## **A46 Newark Bypass**

**Scheme Number: TR010065**

### **7.62 Comments on submissions received at the previous deadline**

**Comments on submissions received at the previous deadline**

Photomontage 25: Year 15 in operation (planar projection, field of view 39.6 degrees x 27 degrees, to be viewed at A3)

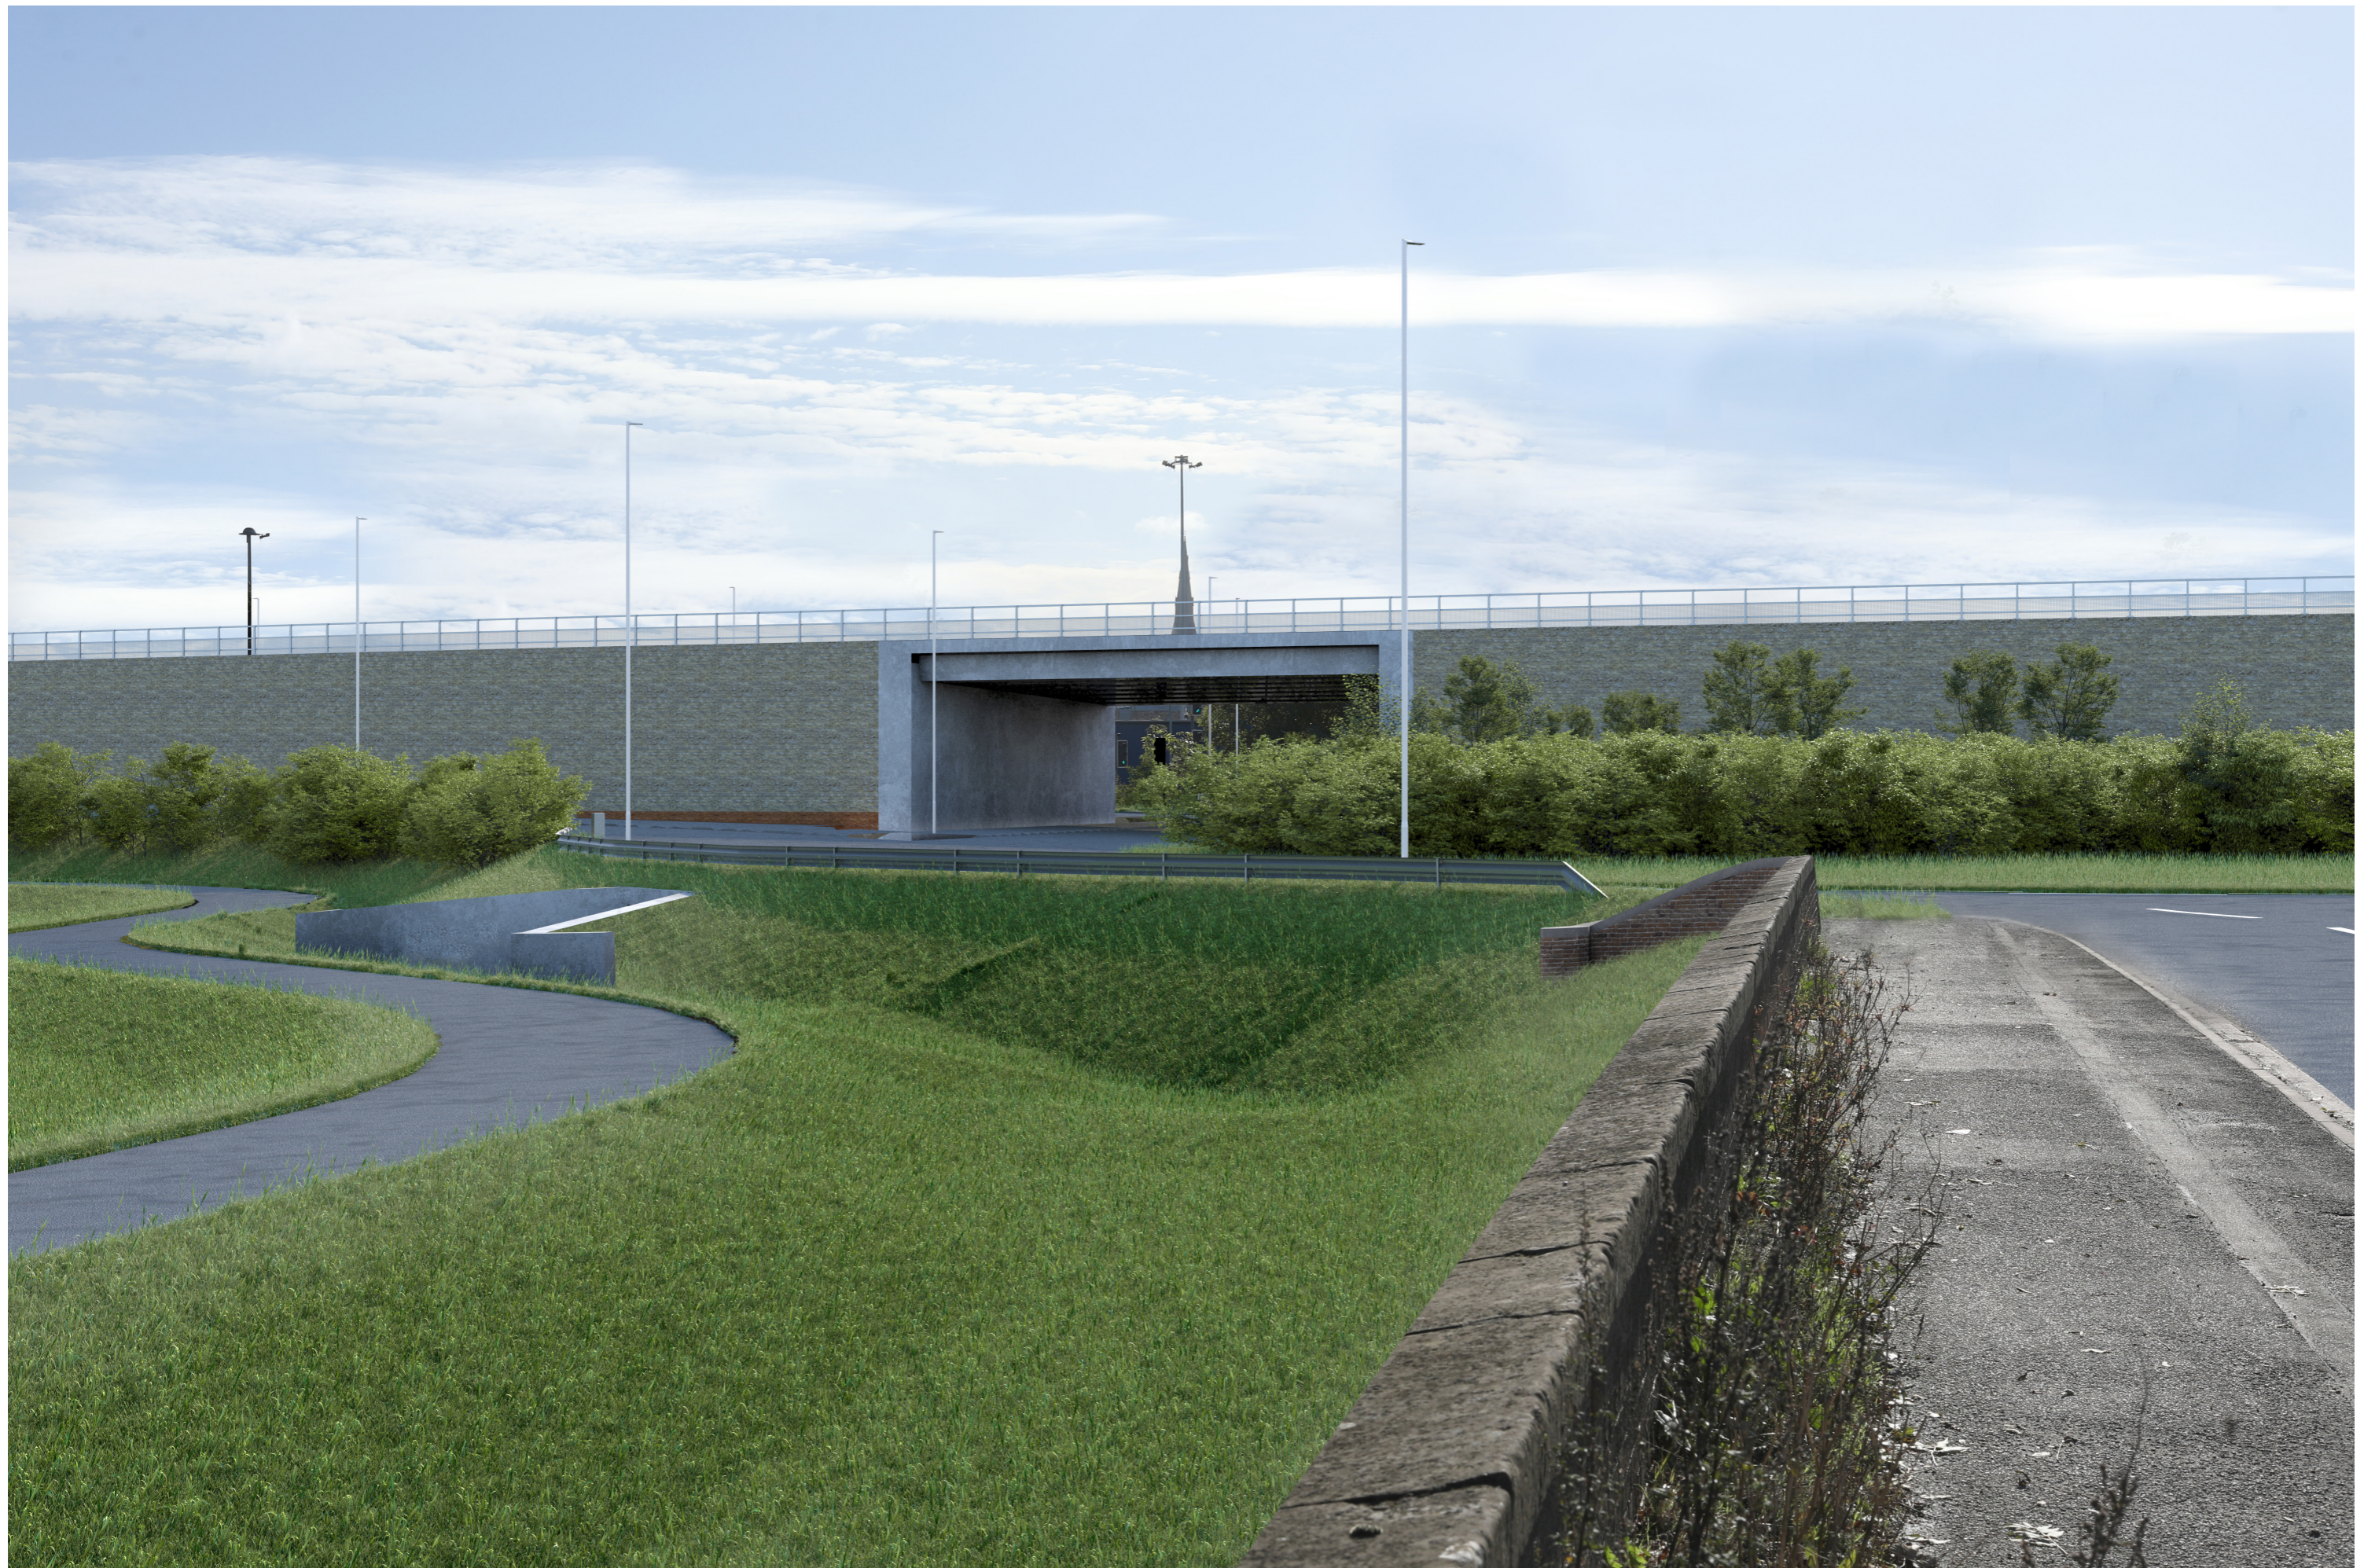
2.26.	<b>Item 4a)</b> Cattle Market junction – The Council reiterates that the landscaping around this junction is insufficient to respond to the character or to provide sufficient mitigation to the impact of the flyover. At present the landscape is dominating with the infrastructure low lying in most places (especially on this roundabout section). To create	The Applicant confirms that at the location of representative viewpoint 25, as assessed within Chapter 7 (Landscape and Visual Effects) of the Environmental Statement [APP-051], roadside vegetation does frame views of the highway looking south to Cattle Market Junction and will continue to do so during the operation of the Scheme, as it will be sufficiently retained during construction
